**Date:** December 13, 2017

**RE:** VA-17-010 Cut to the Chase Equipment Yard

This letter, along with the revised plan, is in response to your comment review letter dated November 21, 2017. The original comments provided by the review agencies are provided along with the applicant response in **Red**.

COVER NOTES AND DETAILS

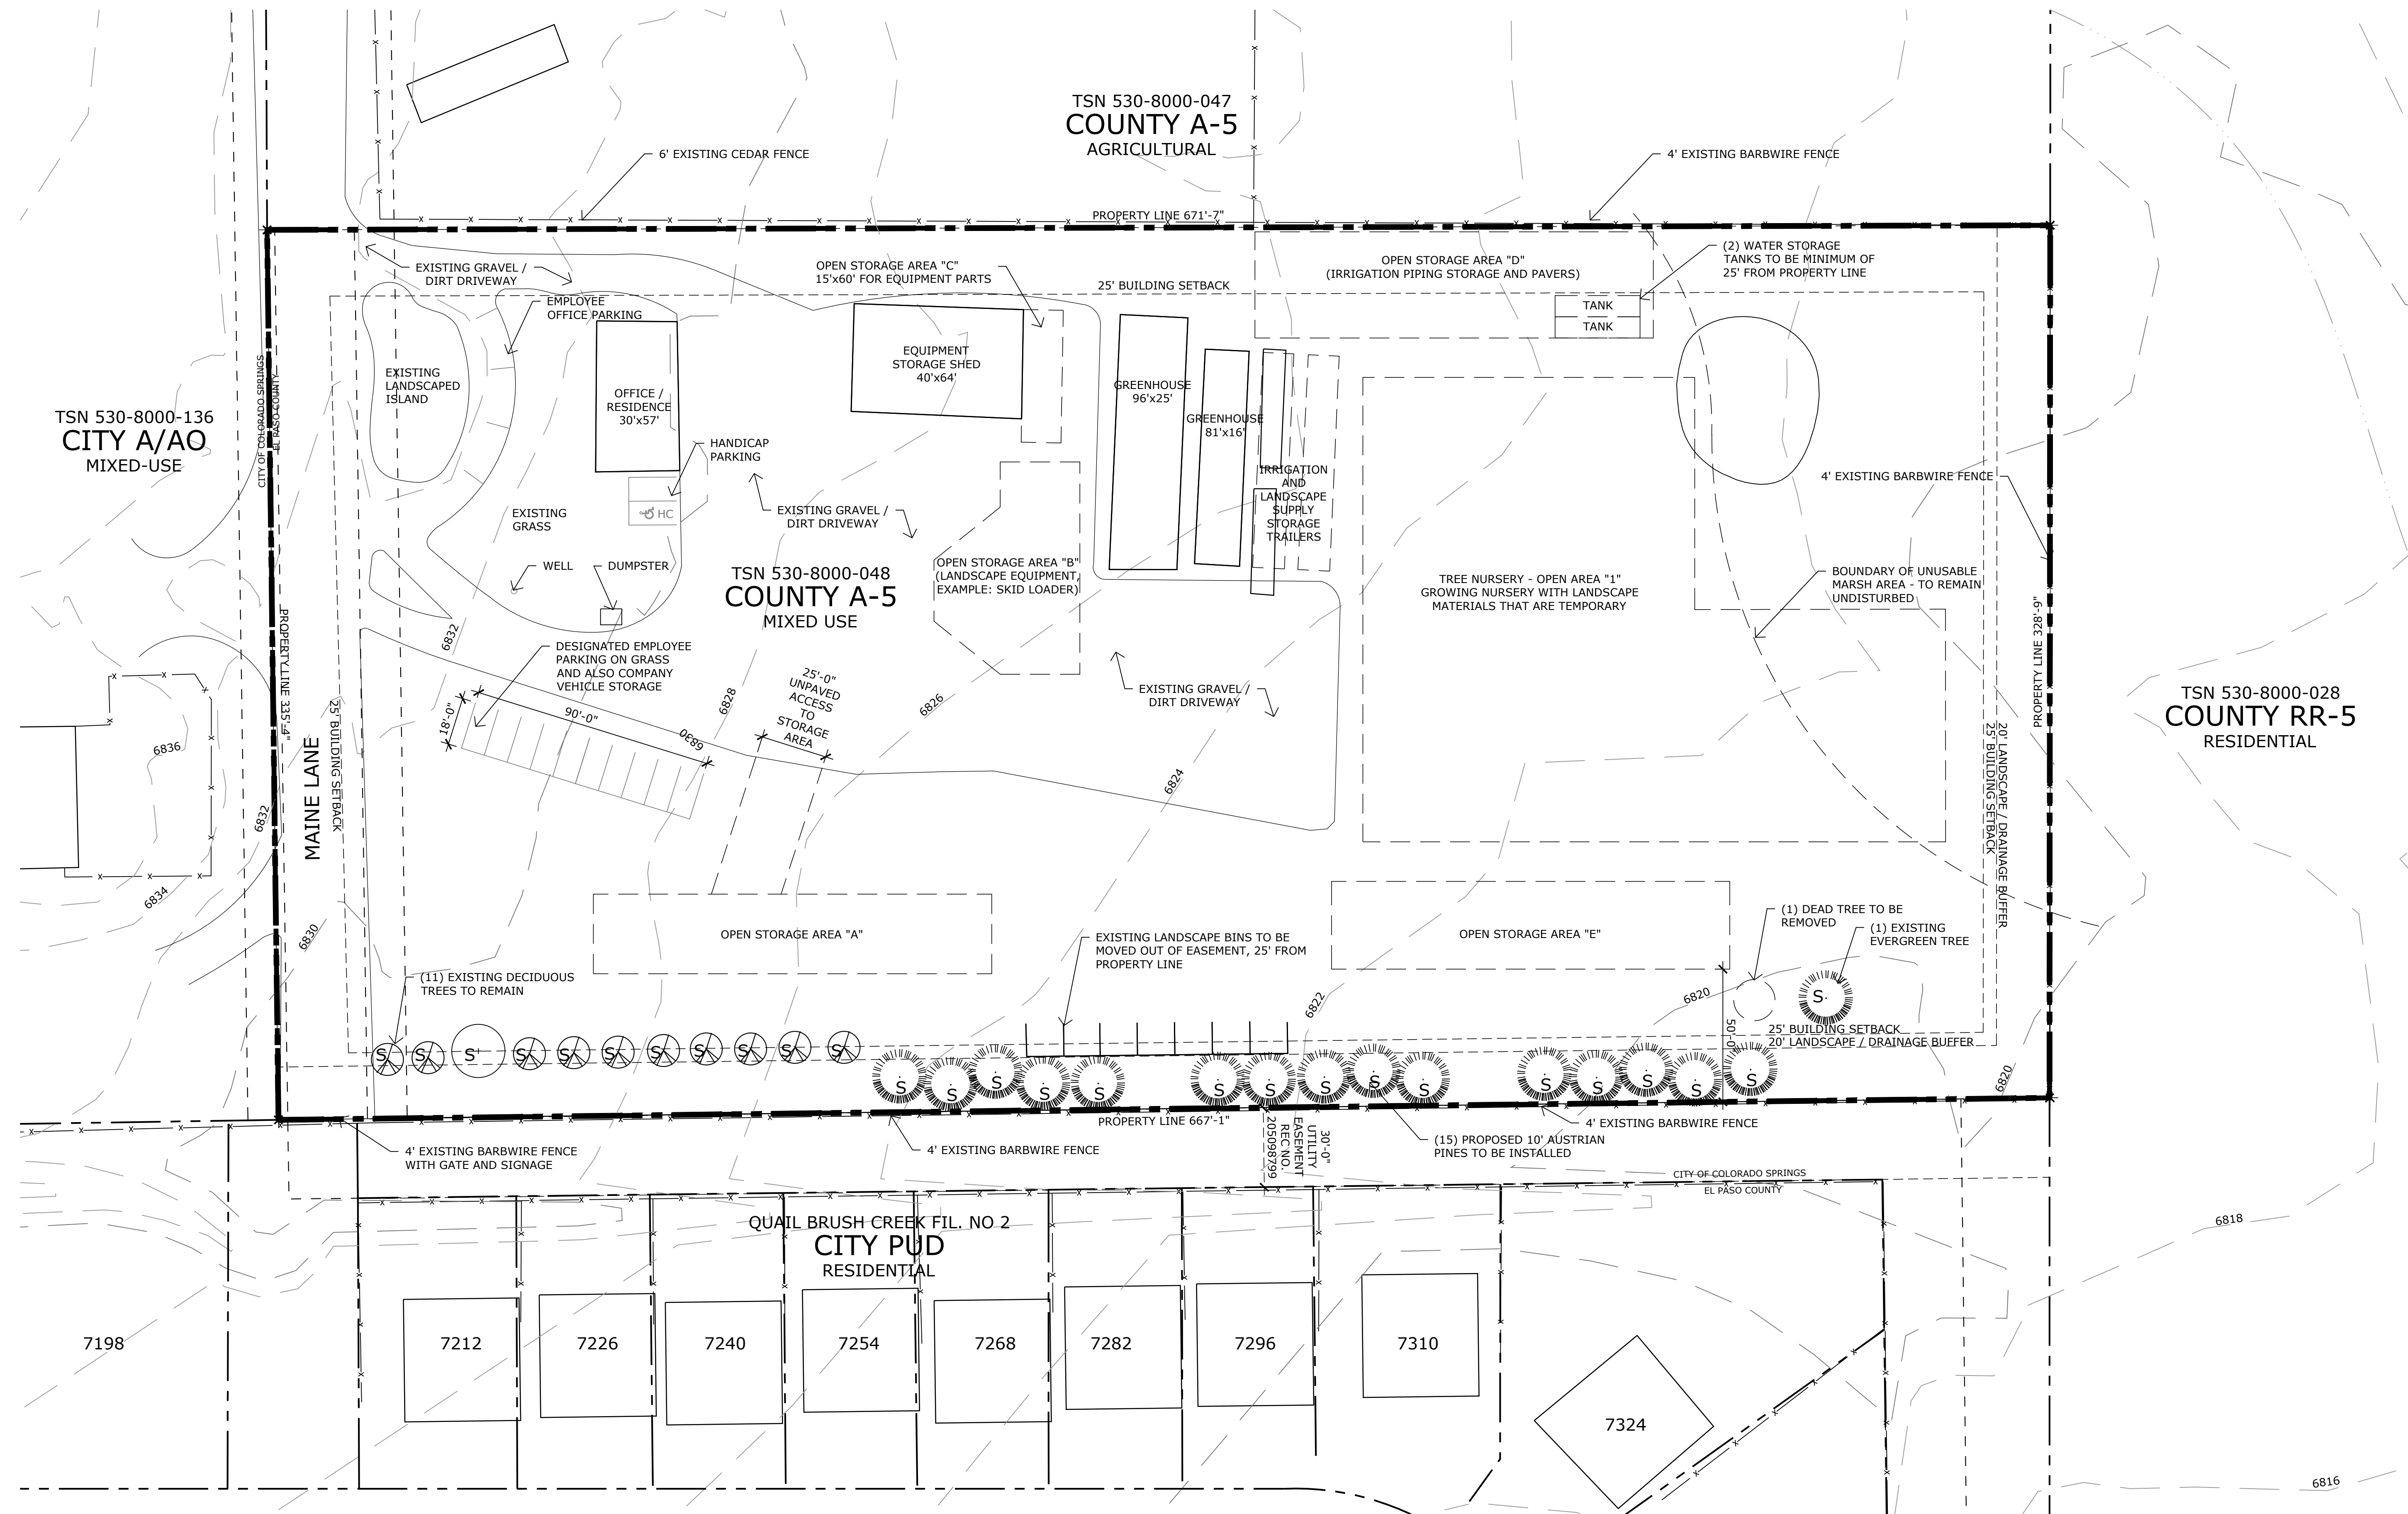
1. See Redlines

- Parking: The area identified as employee parking will remain grassed. One handicapped van accessible parking has been identified on the site plan adjacent to the residential/office structure.

- Tree Nursery: The area needed for the tree nursery has been modified on the site plan. This area reflects current aerals as noted by County staff.
- Screening:

- A 6' opaque fence will be installed along the south property boundary. This fencing will provide screening of outside storage areas as well as provide buffering between the non-residential and residential districts.

- The Applicant is requesting that the required number of trees (1 tree for every 25 feet of property line) along the south property boundary be reduced. As seen on the site plan, three (3) clusters of three (3) Austrian Pines have been strategically located to provide screening together with the existing delicious trees. The Austrian pine can grow up to a height of 50–60' with a spread of 20–40' at maturity and will provide sufficient screening.

- A note has been added on the site plan that any vehicle(s) or outside storage that exceeds the height of the fence shall be a minimum of 50 feet from the residential district.
